Appeal Decision

Appeal Ref: APP/R5510/D/21/3285484

245 Park Road, Uxbridge, UB8 1NS

- The appeal is made under section 78 of the Town and Country Planning Act 1990 against a refusal to grant planning permission.
 - The appeal is made by Mr S Imam against the decision of London Borough of Hillingdon.
 - The application Ref 76478/APP/2021/2871, dated 1 June 2021, was refused by notice dated 1 October 2021.
 - The development proposed is two storey front extension.
-

**Proposed Double Storey
Front Extension.**

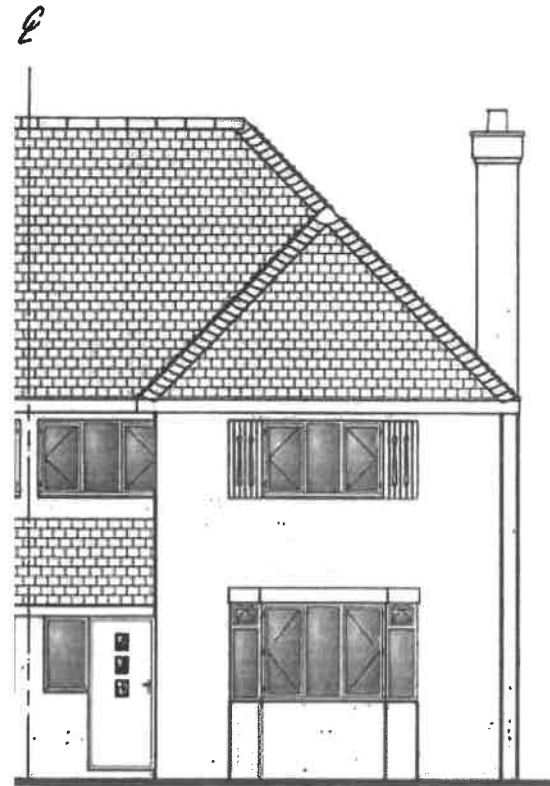
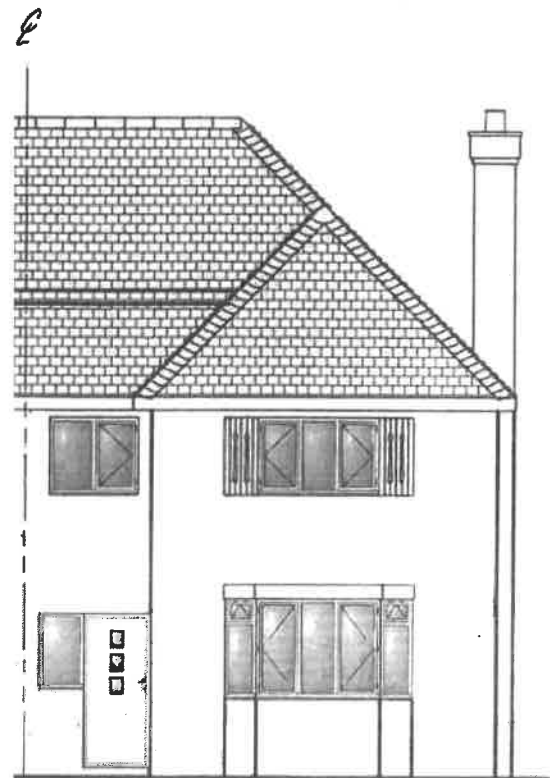
5. The proposal is an in-fill to the front elevation of the dwelling in order to extend the hall with an enlarged bedroom above.
6. The pair of semi's is closely associated with the adjacent pair of semi's that also shares the same characteristics and symmetry. By extending the house at appeal before me, would significantly distort the character of this set of houses. This would be further reinforced by the proposed roof. The main roof of all four houses is hipped, with the projecting front elements also hipped making a characteristic design feature. The proposed roof configuration would be at significant odds with these distinctive roof features.

7. The houses are clearly visible within the street scene. Even if both occupants would be prepared to undertake work at the same time to retain the symmetry of the pair of houses, the imbalance that would ensue between the semi-detached houses and the adjacent pair at 247-249 would lead to adverse harm arising to the character and appearance of the group, and consequently the street scene.
8. Therefore, to conclude, the proposal would not respect the design features of the original dwelling and lead to harm arising to the distinctive character of the houses as a group of semi-detached houses, and to the street scene. This would be contrary to Policy BE1 of the Hillingdon Local Plan: Part One Strategic Policies (2012) and Policies DMHB 11, DMHB 12 and DMHD 1 of the Hillingdon Local Plan: Part Two Development Management Policies 2020 in their combined design aims.
